From: Eve Hearsey
Sent: 09 March 2012 14:16
To: Planning.Responses
Subject: FW: FORMAL CONSULTATION - FG/16/12/ - COUNTRY FAYRE (ASDA), LITTLEHAMPTON ROAD, FERRING

From: Ian Brewster
Sent: 22 February 2012 11:39
To: Eve Hearsey
Subject: RE: FORMAL CONSULTATION - FG/16/12/ - COUNTRY FAYRE (ASDA), LITTLEHAMPTON ROAD, FERRING

This development at Country Fayre has already been approved and Asda wish to make some changes to the overall scheme which are identified within this application for a Minor Material Amendment (MMA). One of the changes being that the landscaping/planting will be increased to that of the earlier permission.

Proposed Site Plan

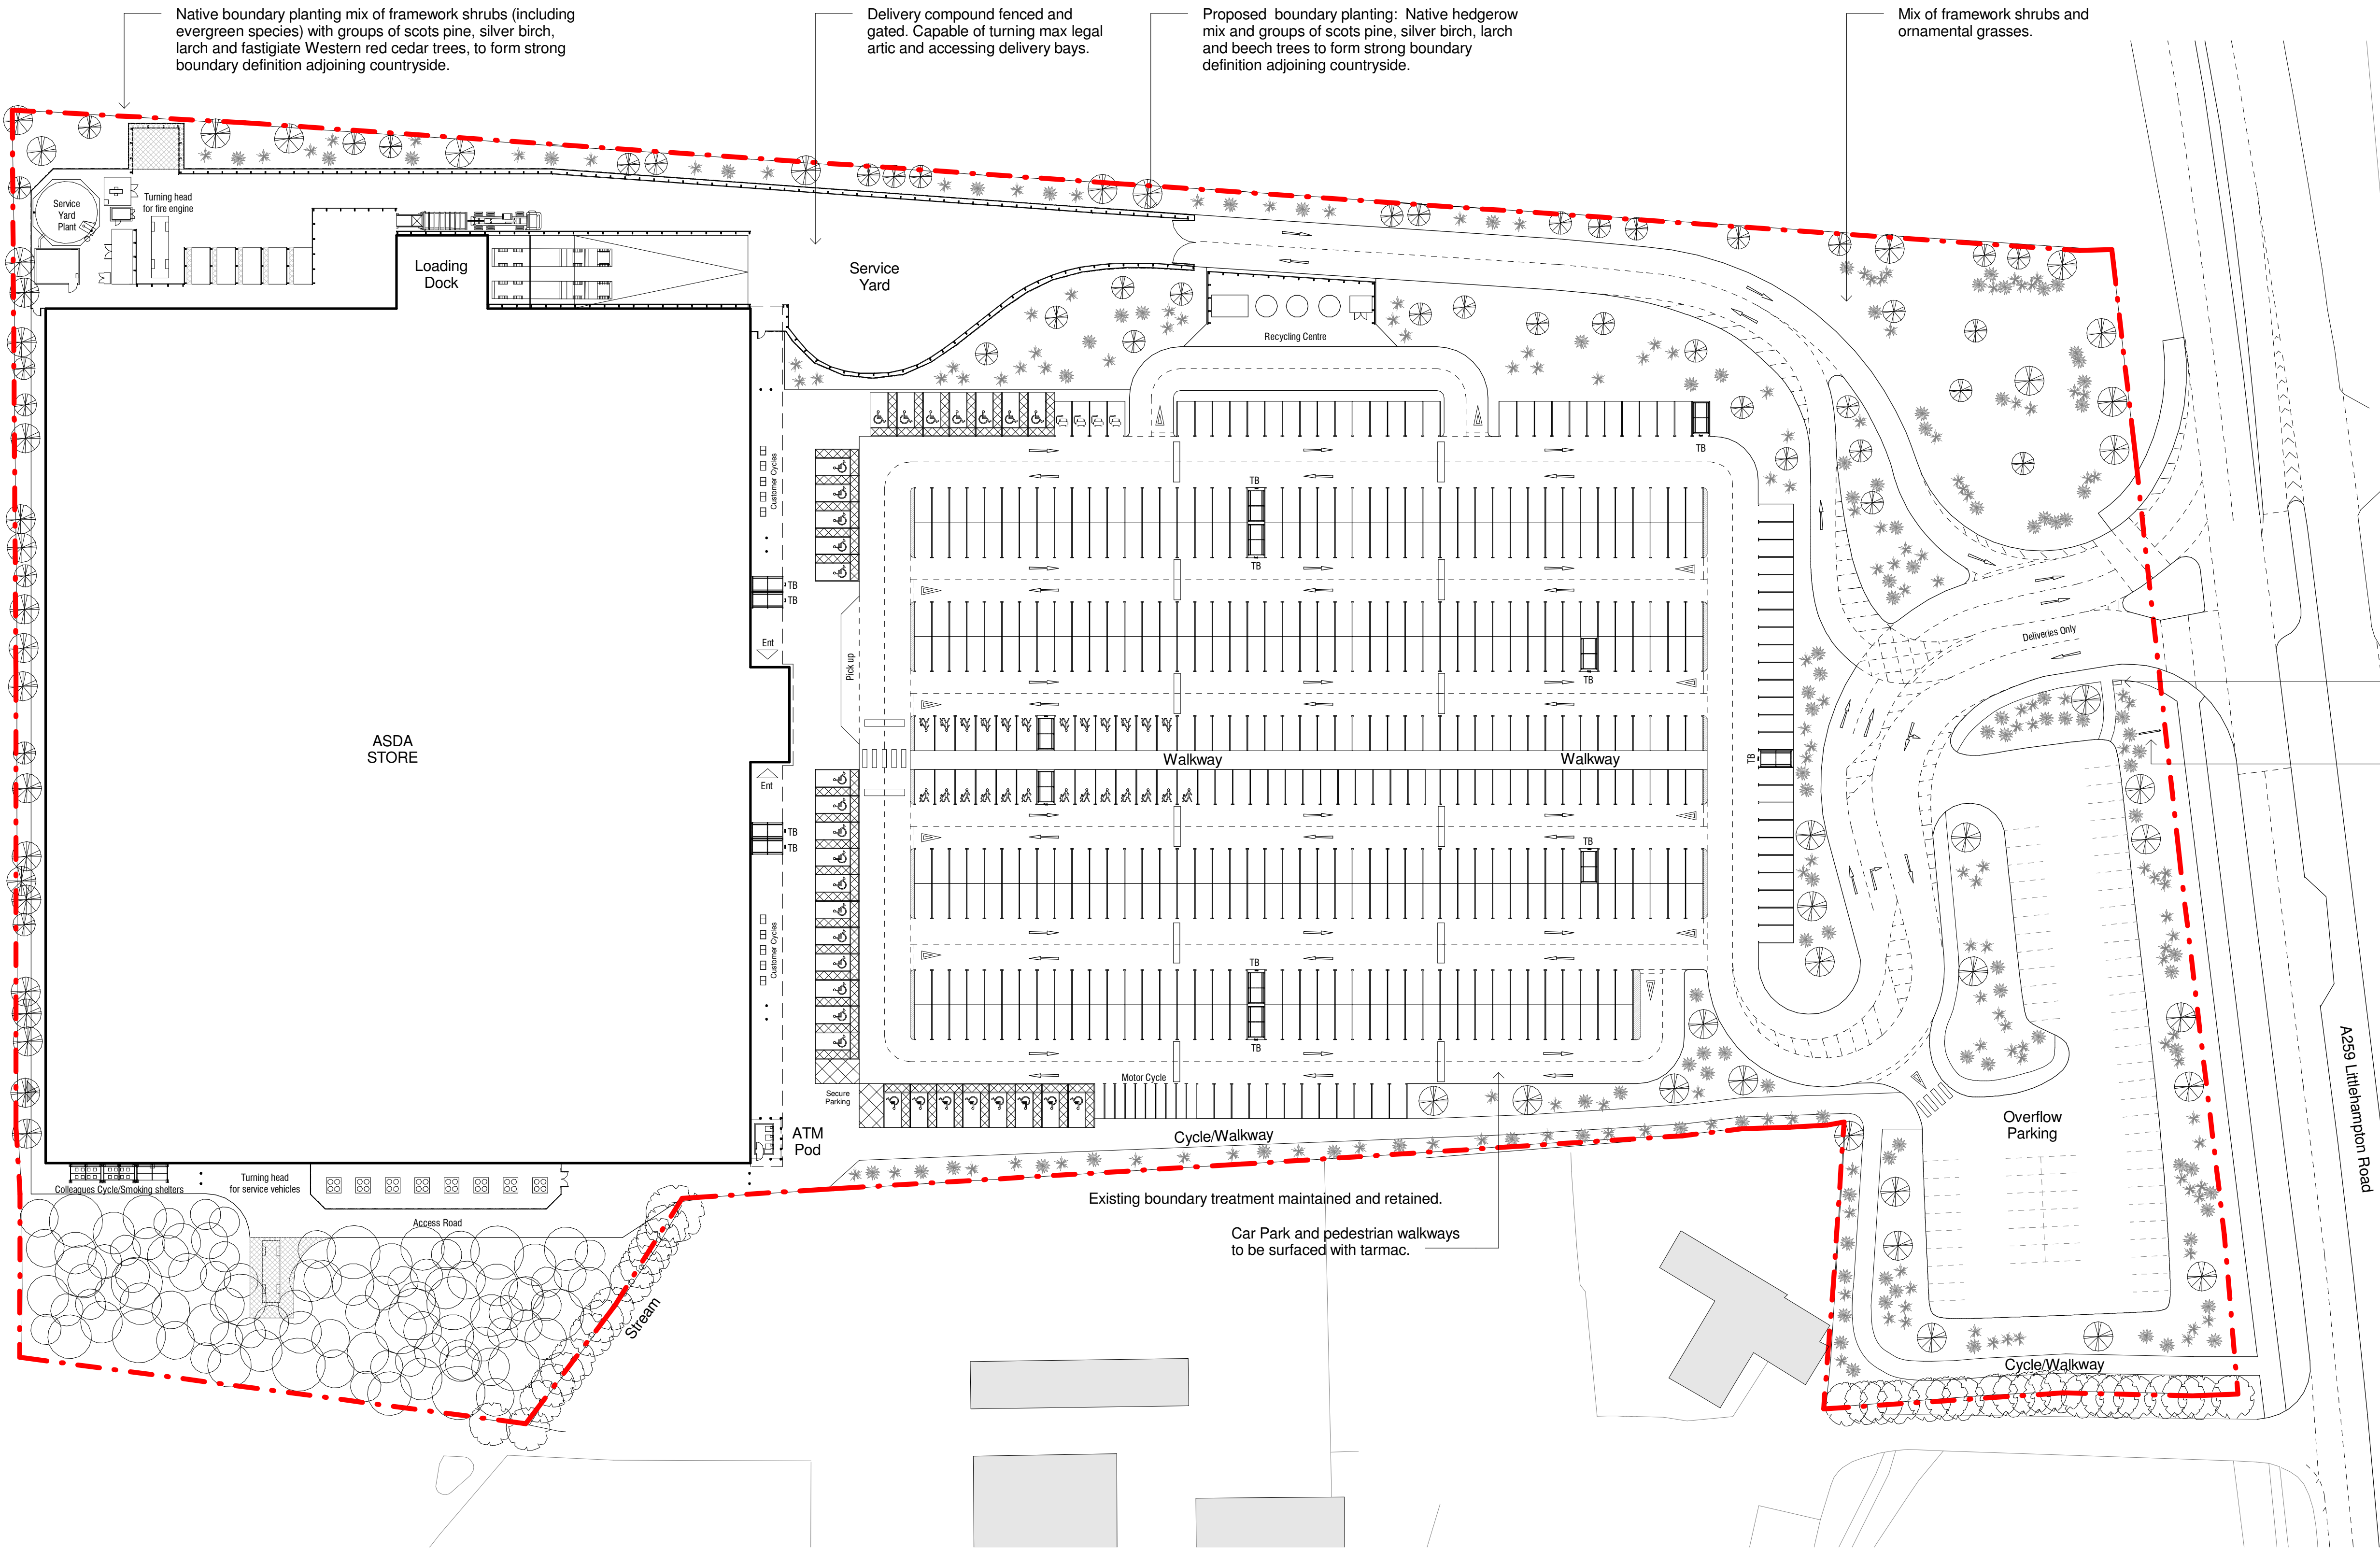
I understand that approval for the ASDA development has been granted. Regarding the planting of trees within the site my comments are based purely from the proposed site plan (scale 1:500), as follows;

The width of the western boundary measures 3.5m. The proposed planting of Scots Pine, Silver Birch and Beech trees will mature and their branches will overhang the access driveway to the loading dock/Service yard. Vehicles using this route will be high sided HGV. Tree planting would need to set at a sufficient distance to reduce the need for drastic pruning work, eliminating the creation of an un-balanced line of trees and increase their life expectancy. It is therefore recommended that the verge is widened to accommodate broad spreading trees or that they are planted at a distance of 0.5m from the boundary to allow at least 3m lateral branch growth without the need for pruning hard back from the driveway. Please note that the planting of Larch is not recommended due to its recent association with the fungal disease Phytophthora. I would suggest provenant and locally sourced English Oak as a possible replacement for Larch.

The overflow car park to the north east is opposite to the planting area (approximately 30x40m) north west and from a visual perspective as viewed from the A259 Littlehampton Road appears unbalanced. It would be appropriate to provide a similar planting scheme/provision for space by halving the overflow car park and supplement the mix of framework shrubs and grasses with trees, suggesting tall, cleared stemmed Scots Pine trees in groups of 3. This would effectively soften and enhance the entrance, adding a natural and prominent landscape feature that would become visible from the highway.
